**Rezoning Transportation Analysis**  
**Petition Number: Insert Zoning Petition #2021-062**  
*General Location Identifier: 14303106*

**Revision Log:**

Date	Description
05-27-2021	First Review (KP)
06-24-2021	Second Review (KP)
07-26-2021	Third Review (KP)

SHEET NUMBER RZ-2.0

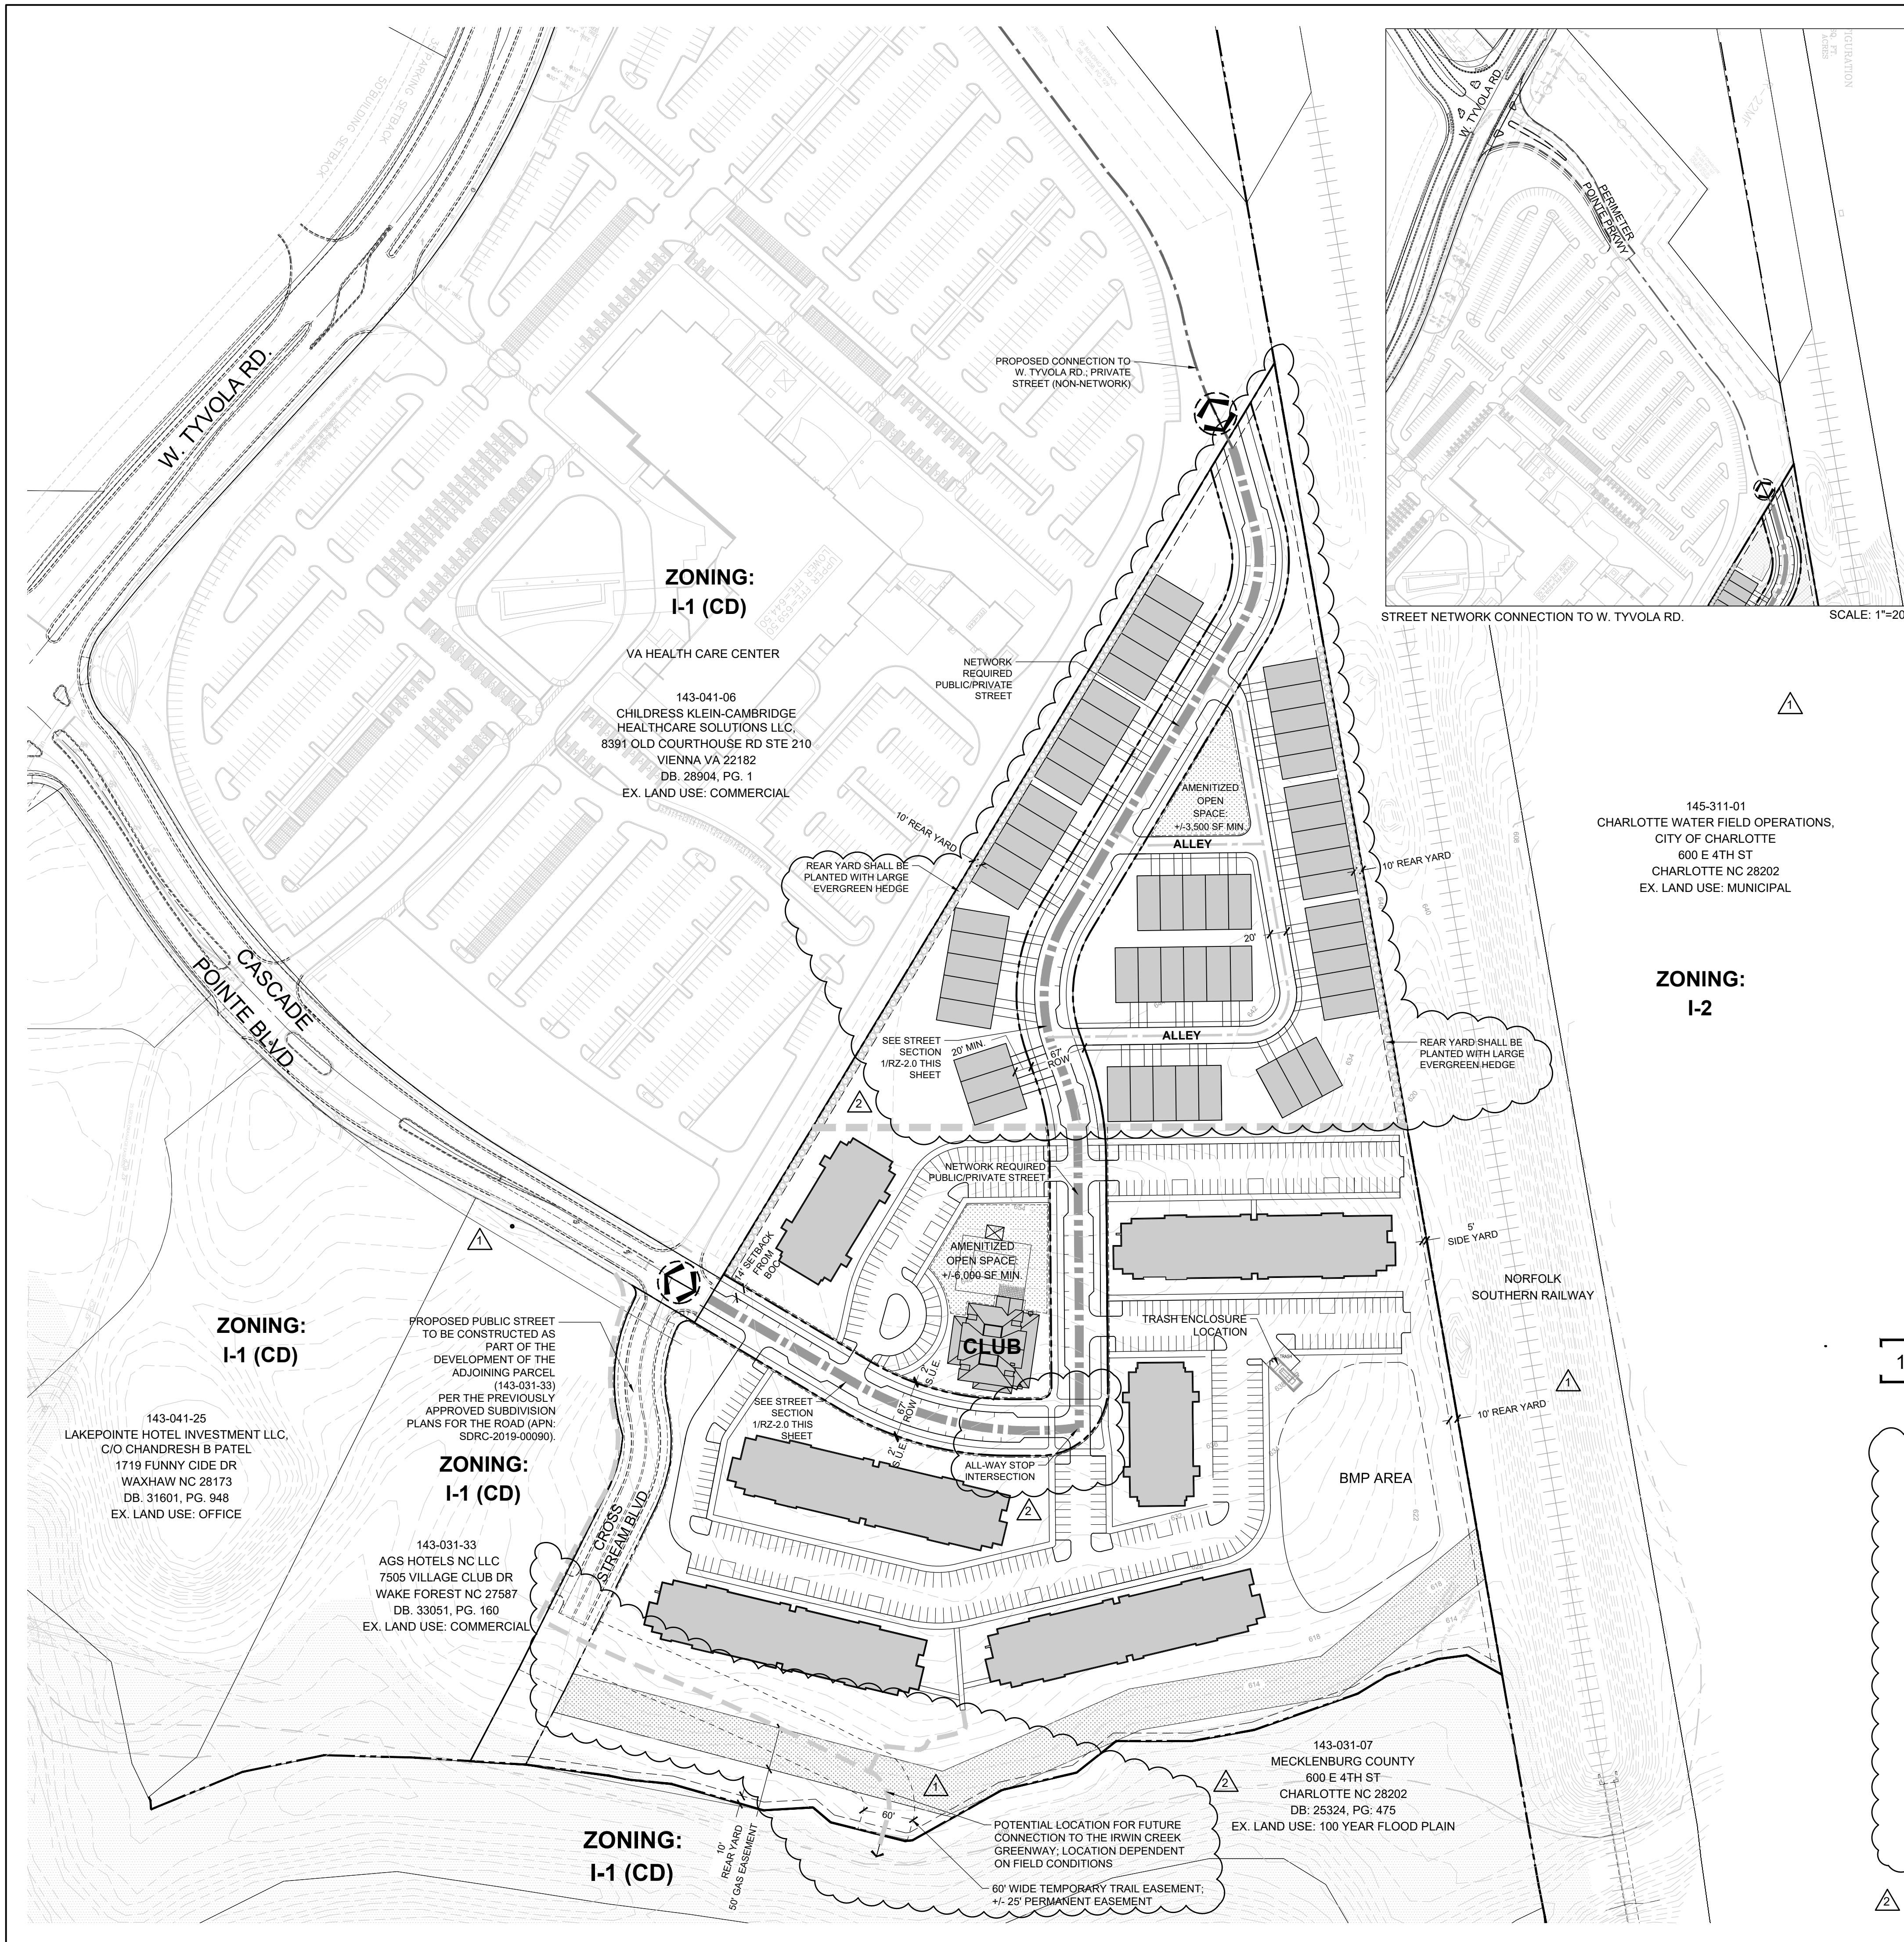
**Update to Comment as a Result of 06-14-2021 Site Plan:** Revise the site plan and conditional notes to commit to constructing this newly aligned roadway/driveway network as an all-way stop intersection with appropriate stop signs and stop bars. Additionally, commit to constructing ADA curb ramps to cross each leg of the intersection.

1 NETWORK REQUIRED PUBLIC/PRIVATE STREET SECTION NTS

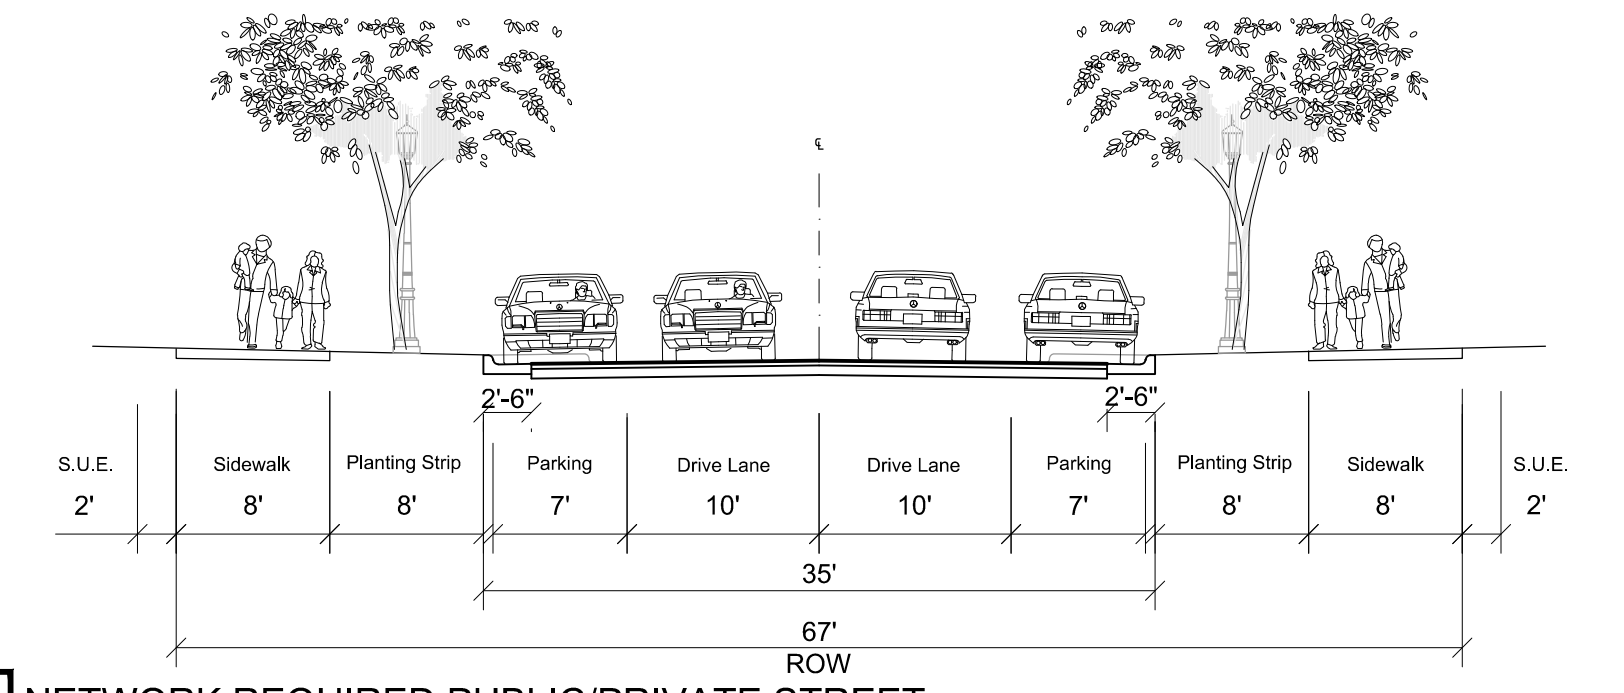
**Update to Comment as a Result of 06-14-2021 Site Plan:** Reference the CLDSM U-03A Local Residential Wide Section for the proposed public street cross section. Secondly, given the proposed density, 8-foot planting strips and 8-foot sidewalks are required along all public street frontages. Revise Cross Section 2 on sheet RZ-2 to incorporate an 8-foot sidewalk, if the street is intended to be public. Third, clearly label the proposed private and public streets and cross sections on the sheet RZ-2, and verify the conditional notes' accuracy and revise accordingly referencing public or private streets, specifically note 3.a. Streets and cross sections shall not be labeled Public/Private and there will be no ambiguity associated with the limits of the public and private street(s) network.

Limits of Public and Private streets need to be determined prior to rezoning approval.
